Ref:- Planning Application BN/128/19

Proposed development of 70 bed nursing home and 14 bed assisted living accommodation on land adjacent to Highfield House, Yapton Road, Barnham

We are submitting this letter of **OBJECTION** to the above planning application for the following reasons.

DATE  
JULY 2019  
JOB / DRWG No  
1693 / SP1

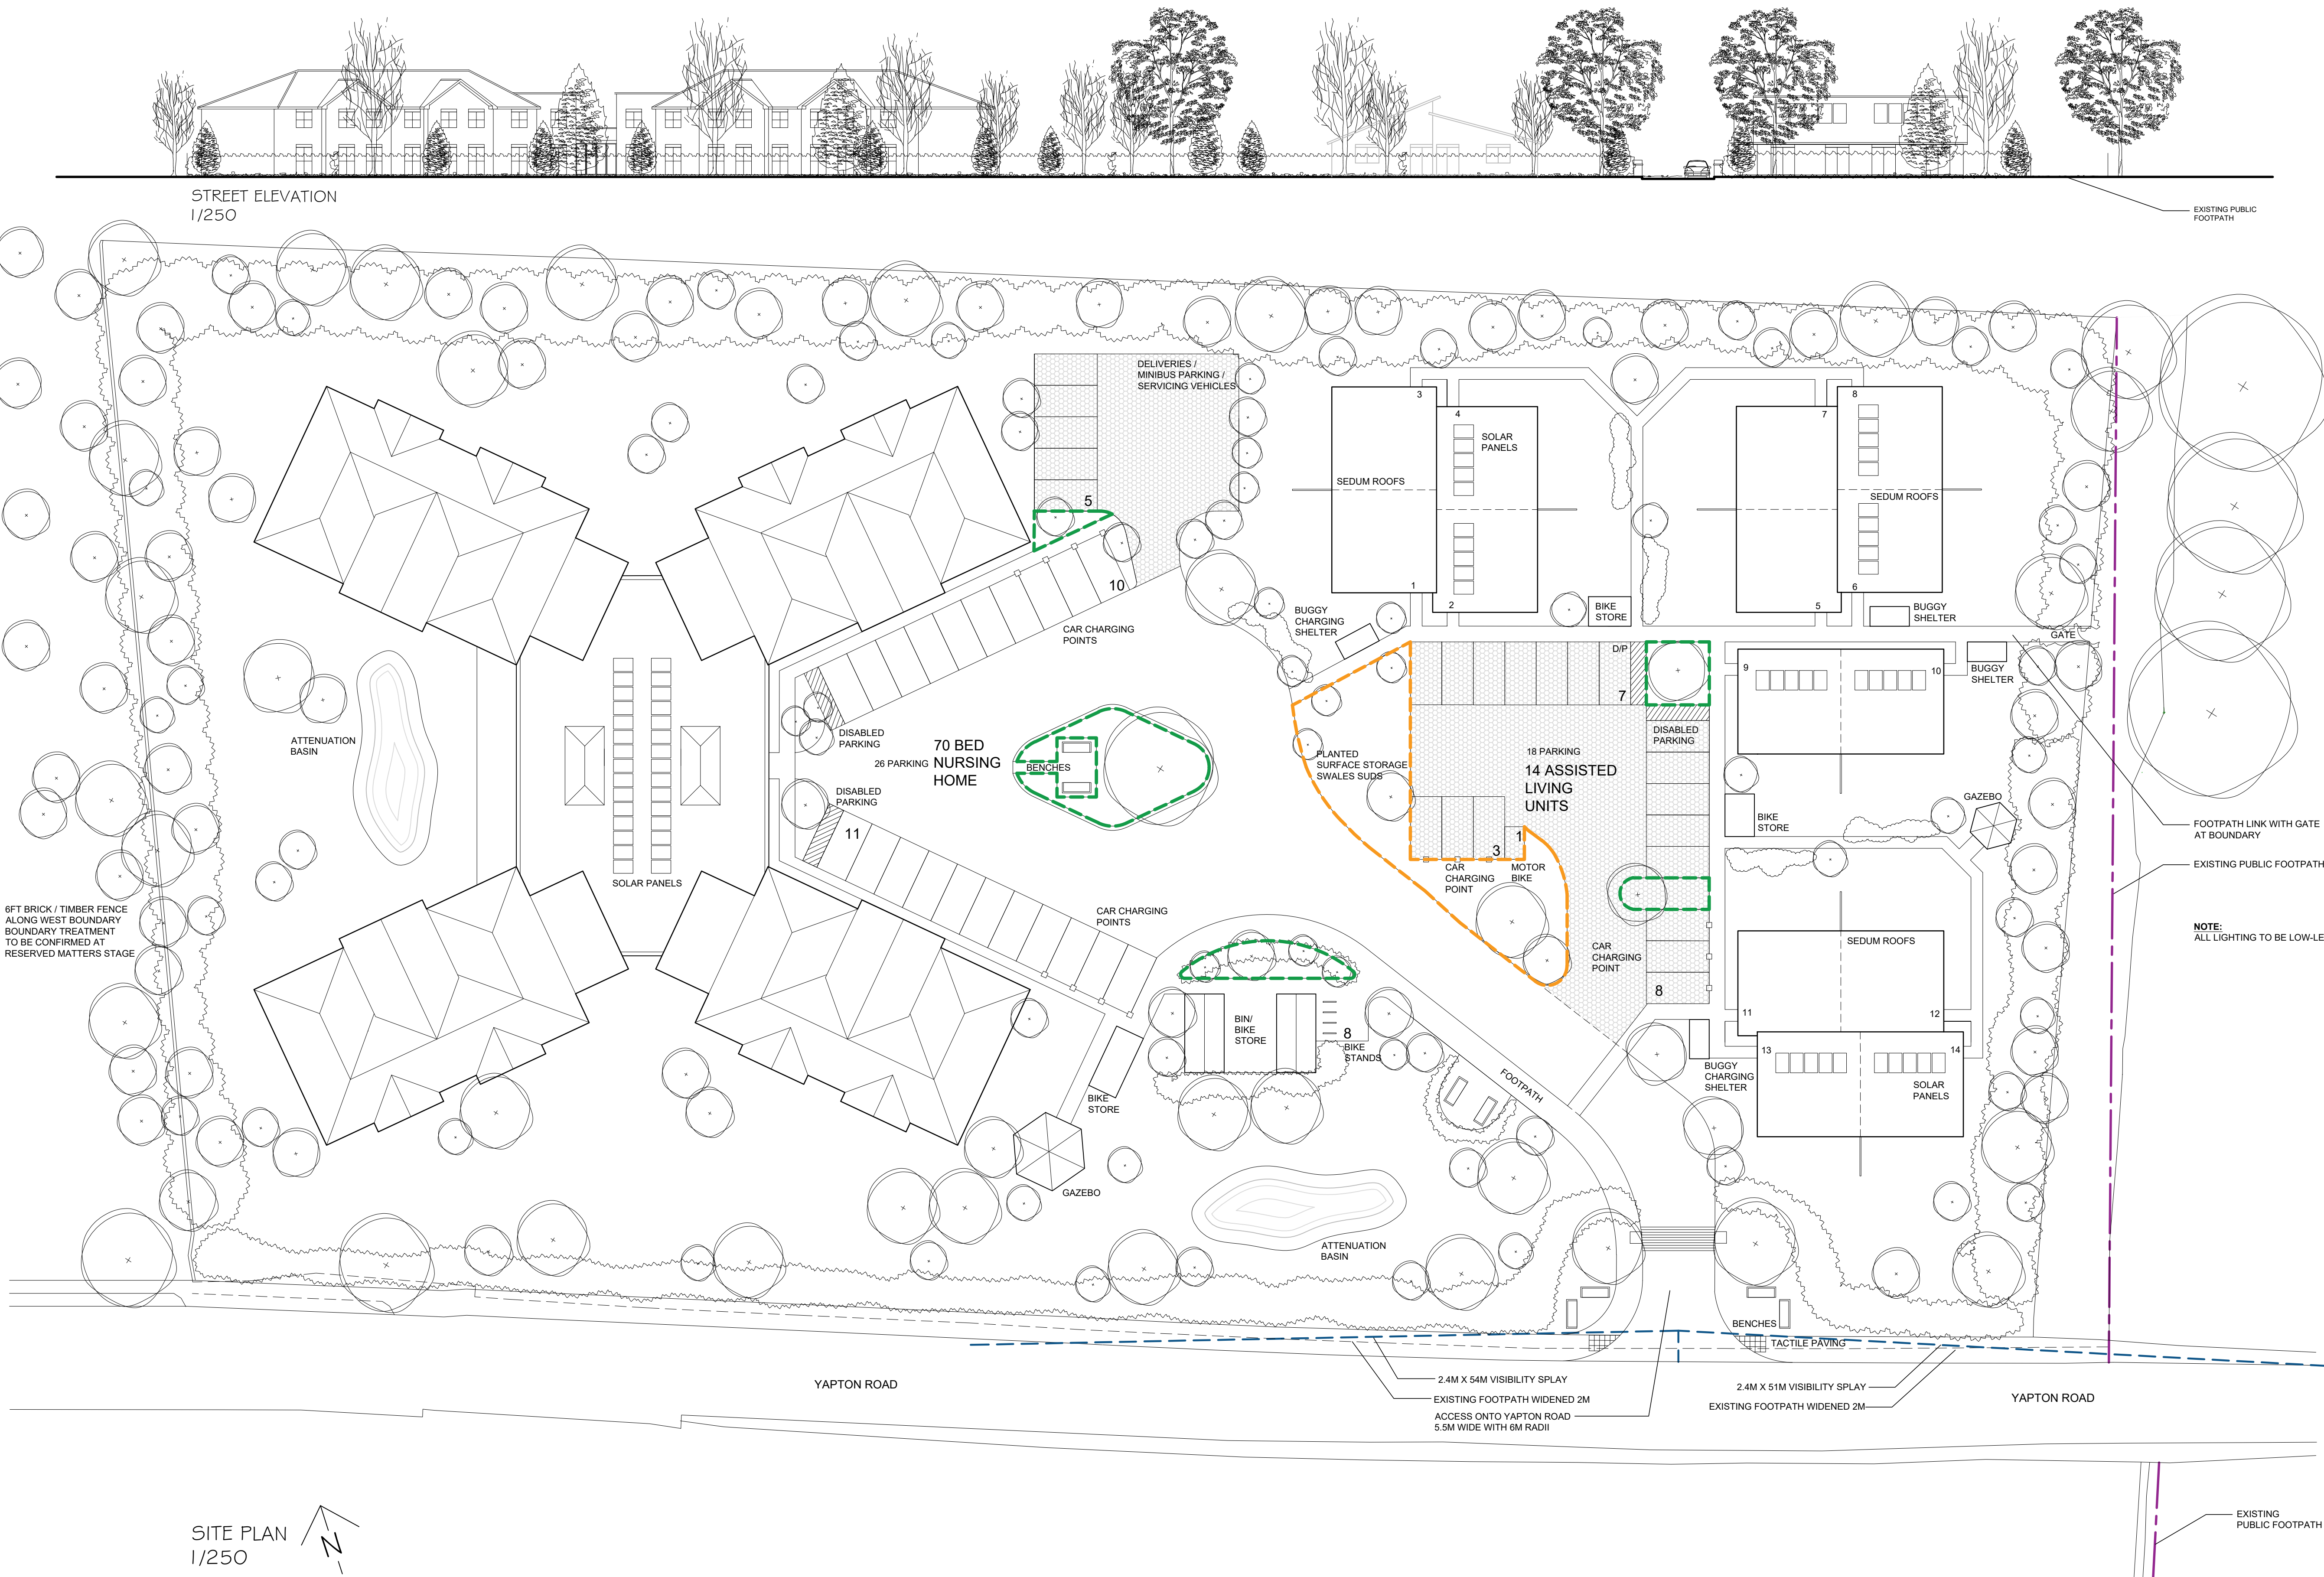
The development is shown on the proposed plans to be two storey and will be screened by a new hedge that will be planted in a position back from the existing hedge which would take many years to mature and become established as an effective screen, to the detriment of the local residents living across the road from the new development.

This type of development will need twenty four hour external lighting introducing light pollution into an area with no existing street lighting, which will be to the detriment of the local residents living on the opposite side of Yapton Road.

The car park capacity of the proposed development is fairly minimal only allowing for basic staff parking and a few visitors, this doesn't allow for peak relative visiting periods such as special events laid on by the nursing home to encourage relatives to visit and special holiday times such as Easter and Christmas. Yapton Road is not a safe road to use for overflow parking and the nearest possible overflow parking is Barnham Village Hall which is a long way to walk to the proposed Nursing home along a single footway path.
